File No: R/2015/21/C  
Your Ref: SSD 7080

**RE: Proposed mixed use residential and retail development at 80-88 Regent Street, Redfern (SSD 7080) – Revised Response to Submissions (RTS)**

## Attachment A: Review of Response to Council Submission

2 Winter 2pm Proposed
0501 1 : 1000@A1

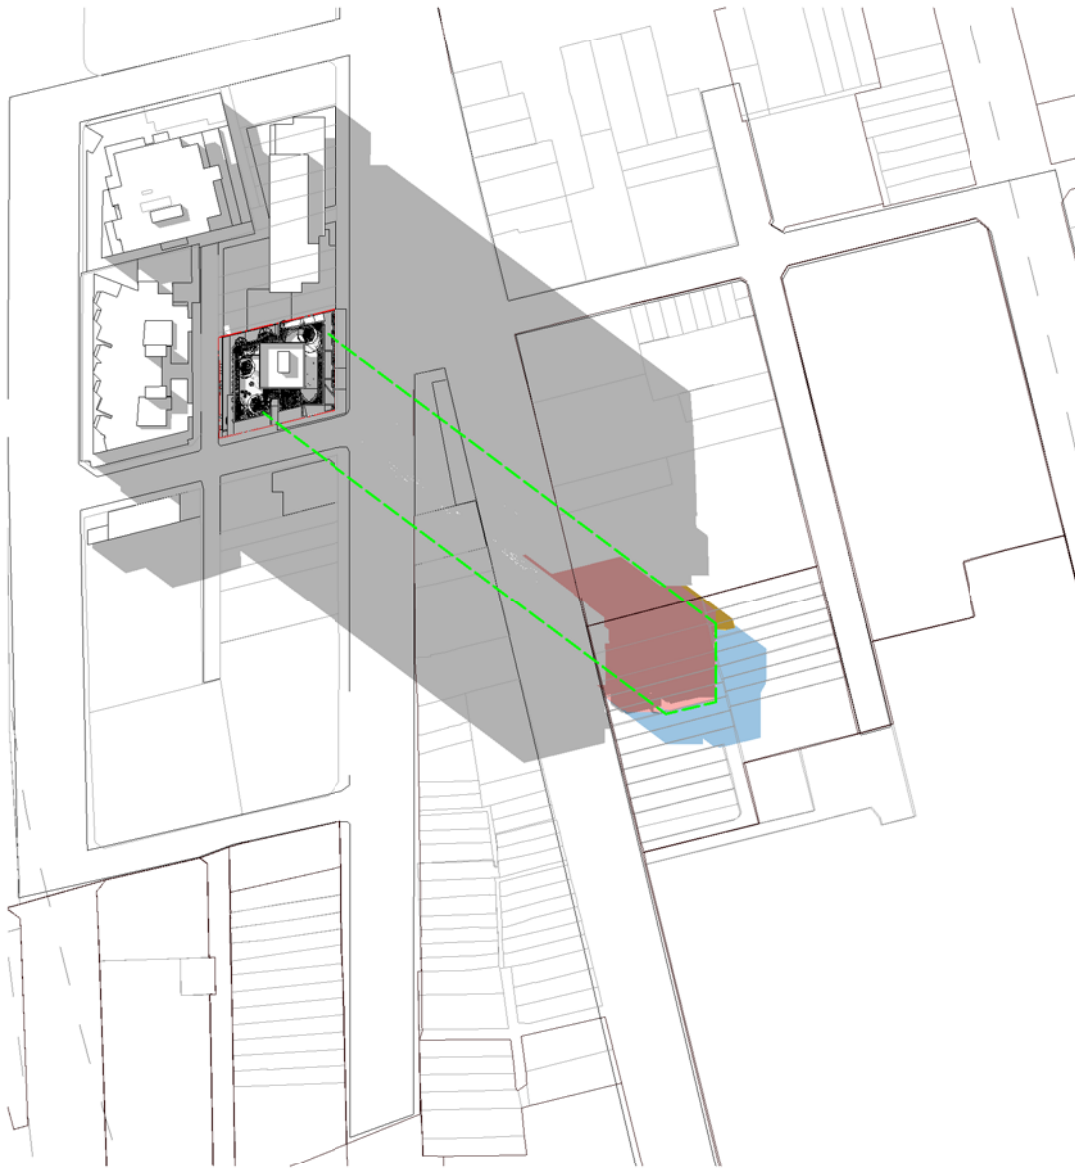
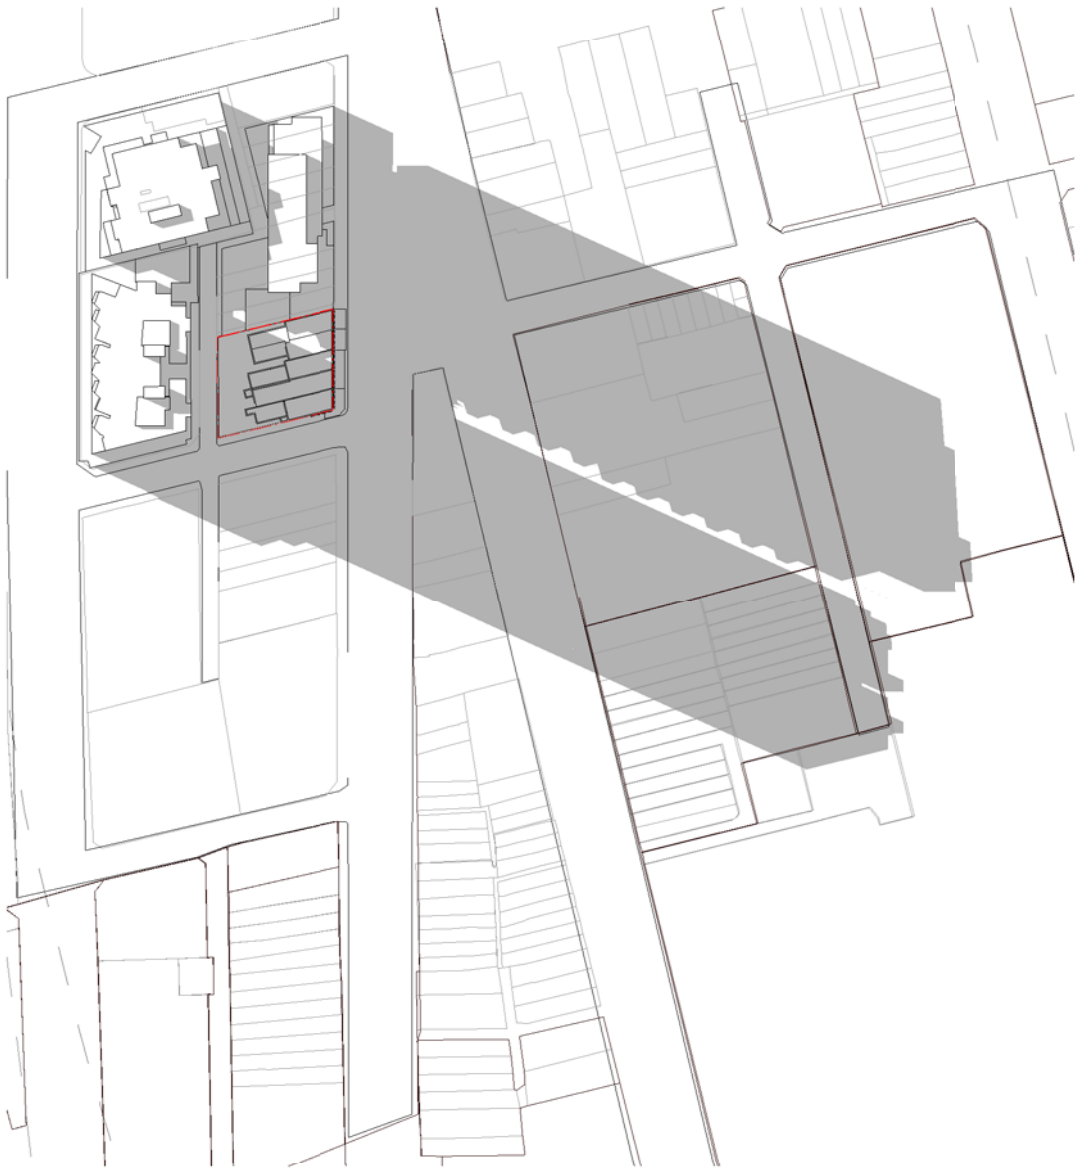
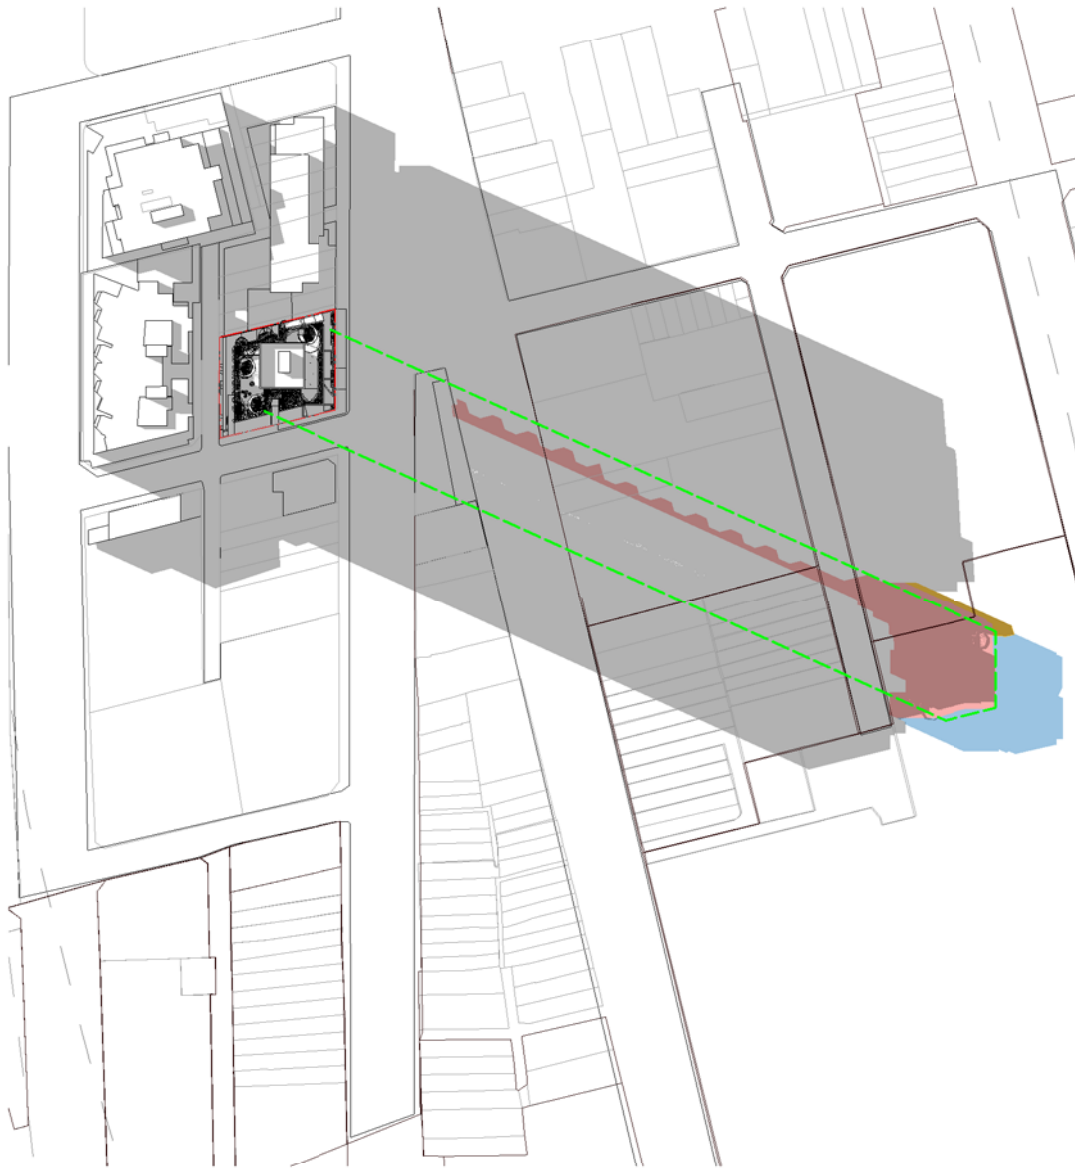
- The shadow diagrams are unclear in demonstrating the extent of the shadow cast by the current proposal. In order to understand the impacts arising from the revised building envelope, a shadow diagram illustrating a compliant 8-storey scheme and the proposed 18-storey proposal should be prepared.

- It appears the proposal will overshadow residential apartments at 1 Margaret Street and the adjacent Gibbons Street Park. A detailed shadow diagram should be prepared illustrating the shadows cast on winter solstice for both sites, in addition to elevational shadow diagrams for residential apartments.
